DEPARTMENT OF PARKS AND COMMUNITY SERVICES

March 27, 2023

Subject: FourSquare at Sterling Ranch East Filing No. 1 PUD Development Plan and Preliminary Plan, Submittal #2 – Final Comments (PUDSP-22-007)

FourSquare at Sterling Ranch East Filing No. 1 Final Plat, Submittal #2 – Final Comments (SF-22-036)

TRACT H
PROPOSED FULL SPECTRUM
DETENTION POND 16A
488,118 SF
11.21 AC

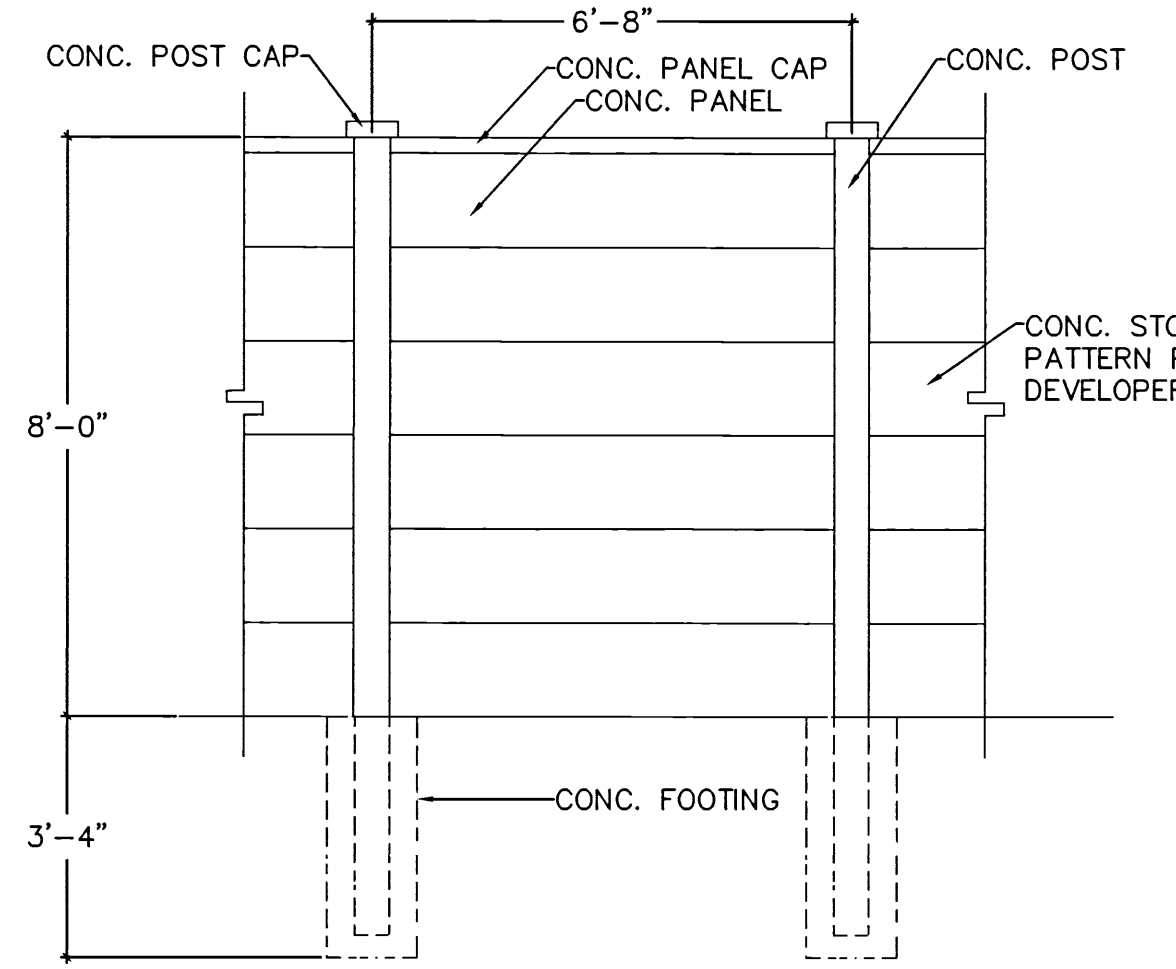
Staff is pleased the FourSquare at Sterling Ranch East Filing No. 1 Final Plat contains a large percentage of passive-use park and open space areas, however, the inclusion of the large regional stormwater detention facility in the open space calculations as a dual-purpose drainage and recreational facility is concerning. As noted above, stormwater facilities may only comprise 10% or less of the open space calculations, whereas Tract I comprises 30.5% of the total project area and as noted above, 68.5% of the available open space.

Furthermore, Parks staff highly discourages the construction of recreational facilities in an active stormwater detention facility, especially one of this size and magnitude. In order to maintain a hazard-free recreational environment, a multi-use turf field located at the bottom of the detention facility would need to be adequately fenced from the concrete trickle channels, forebays, and outlet works, thus disrupting the overall efficiency of the detention facility itself.

Because Tracts A through H, at 5.17 acres, comprise over 14% of the total project area and therefore meet and exceed the PUD 10% open space requirement, staff recommends the applicant remove the regional stormwater detention facility from the open space calculations in order to conform to the recommended guidelines of the Land Development Code.

Staff does, however, encourage the applicant to construct the trail and trail-related amenities around the upper perimeter of the stormwater detention facility, keeping user safety in the forefront of plan design. Staff also encourages the applicant to plan and develop active-use amenities within the 2.57-acre neighborhood park, which could include playgrounds, picnic tables and pavilions, and perhaps exercise areas. These types of amenities would allow for a wide variety of recreational choices to users of all age groups and abilities. Lastly, staff recommends fees in lieu of land dedication for regional and urban park purposes, to be paid upon the recording of the forthcoming final plats.
